The Sizewell C Project

5.5 Two Village Bypass Flood Risk Assessment Addendum Appendices A-D

APPENDIX A: EXTRACT OF THE ENVIRONMENT AGENCY RELEVANT REPRESENTATION RELATED TO FLOOD RISK

APPENDIX B: COLLATED COMMENTS FROM THE ENVIRONMENT AGENCY RECEIVED ON 5TH FEBRUARY 2020 AND 4TH AUGUST 2020

Plate 3.2. Updated 1D-2D model extent.

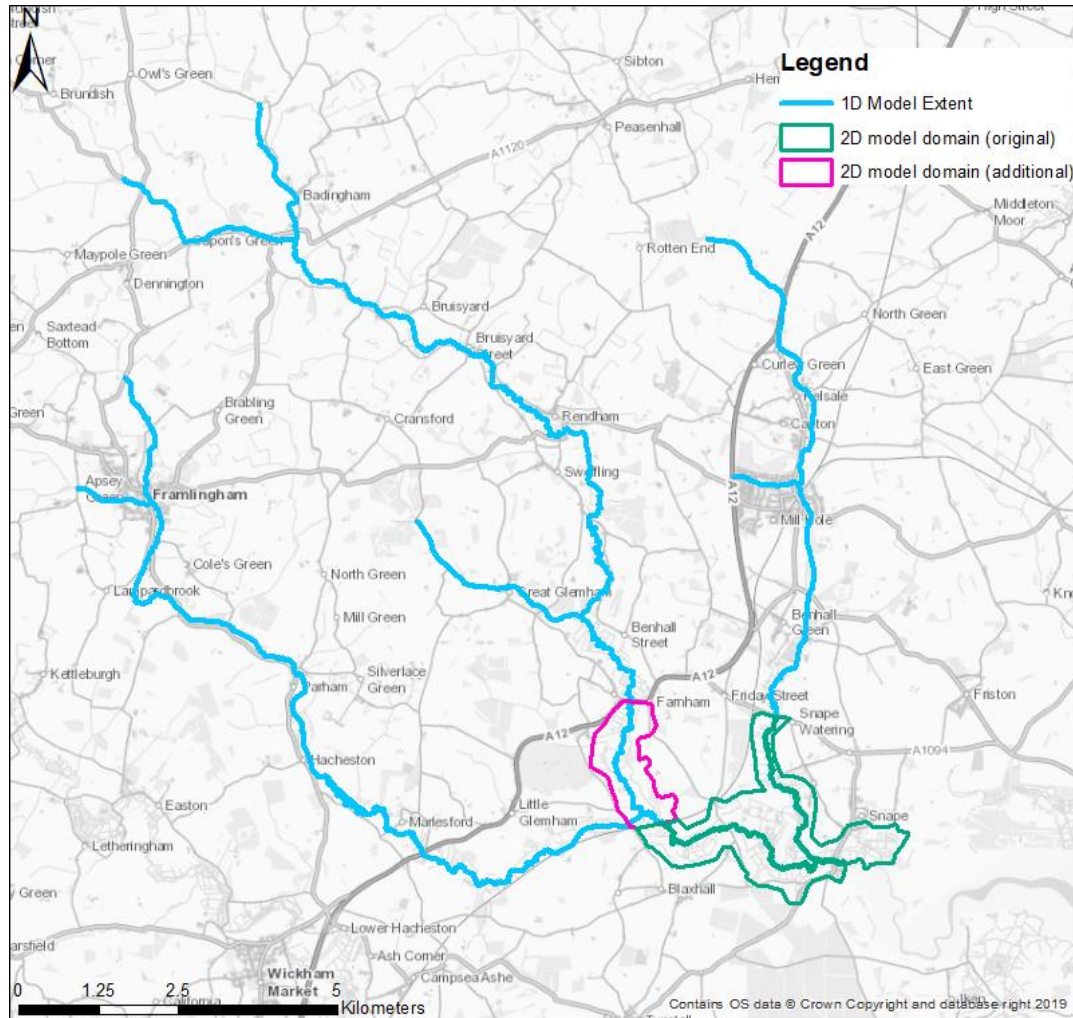
2.8	2VB Hydraulic Model	n/a	Stability patch roughness value very high	2D roughness values generally appear sensible, with the exception of a stability patch of 0.85 applied along all banks throughout model. This value is very high and requires further justification as to its use. .tmf states that it is for grassed banks, but the "patch value" is much higher than the standard value for grass (is closer to a value used for solid buildings).	Provide justification or amend Mannings's n values for stability patch	2	05/02/2020	Sensitivity test has been carried out within the modelling. The results of this have been presented in the FRA Addendum and accompanying Modelling Report Addendum.
3	2VB Hydraulic Model	n/a	Sensitivity testing	No indication of sensitivity testing other than on pier width and referring to sensitivity testing undertaken in the 2012 study. It is recommended that sensitivity testing is undertaken on the parameters selected by the modeller to provide evidence on the effect of these assumptions on the potential conclusions.	Undertake sensitivity tests on manning's roughness values and DS boundary conditions	2	05/02/2020	Sensitivity test has been carried out within the modelling. The results have been presented in the FRA Addendum and accompanying Modelling Report Addendum.

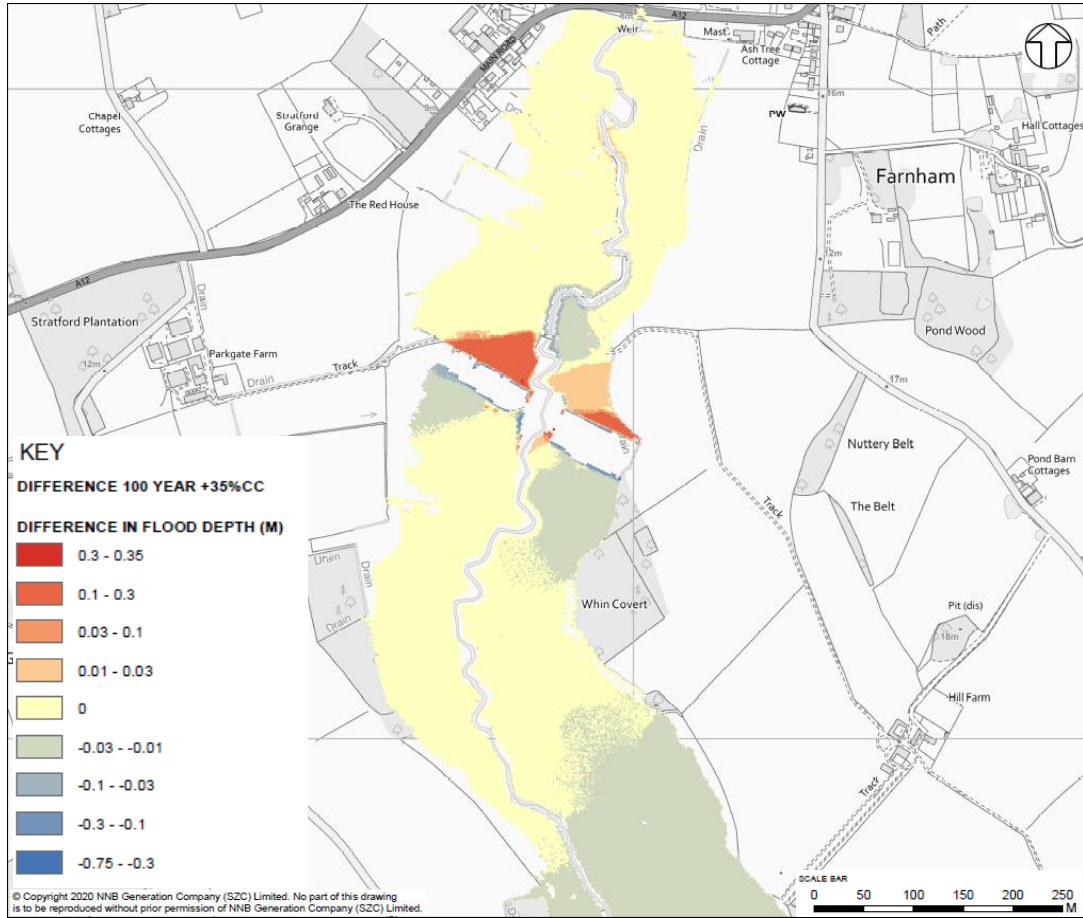
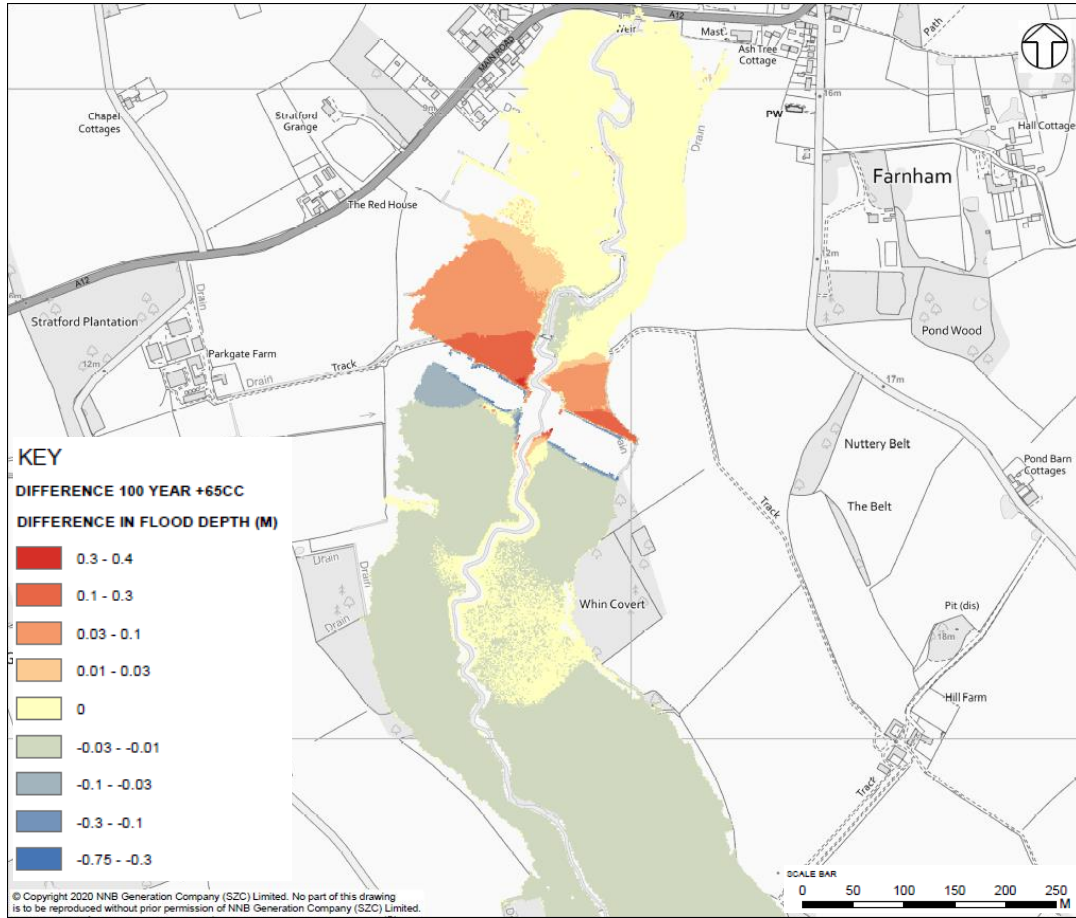
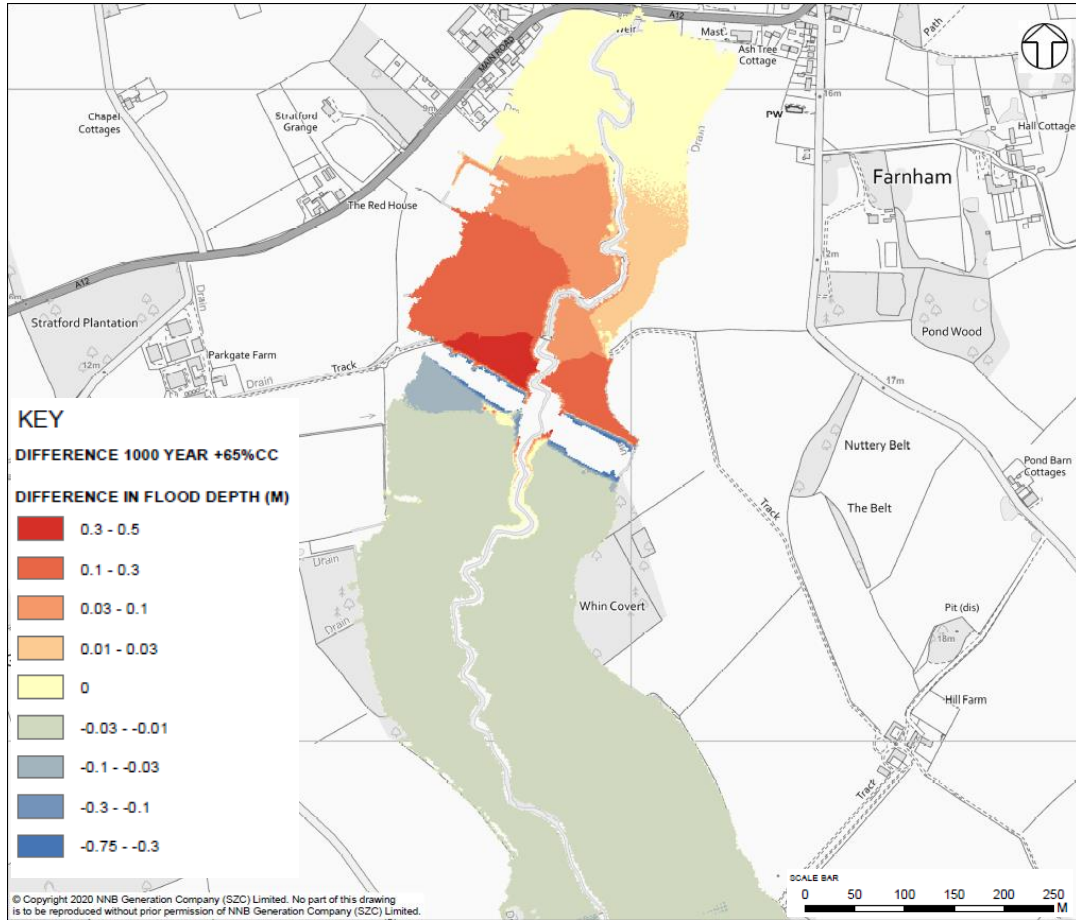
10.9	Two Village Bypass Fluvial Modelling Report	Appendix C Figures C.10 & C.11	Figures show changes is flood depth including those below 3cm and decreases. Changes are not discussed in the FRA or model report.	The figures show that there are large areas of decreases in flood depth both upstream and downstream of the crossing which is not discussed or explained. There are also areas of increased depth adjacent to the channel further upstream below 3cm which are not mentioned in the reporting.	Please provide a full discussion on the changes in flood risk, increases and decreases, to fully illustrate the changes as result of the crossing. Please discuss the changes in flooding mechanism and why depths decrease upstream and downstream of the crossing.	2	05/02/2020	Further discussion of the results has been included in the FRA Addendum and accompanying Modelling Report Addendum.
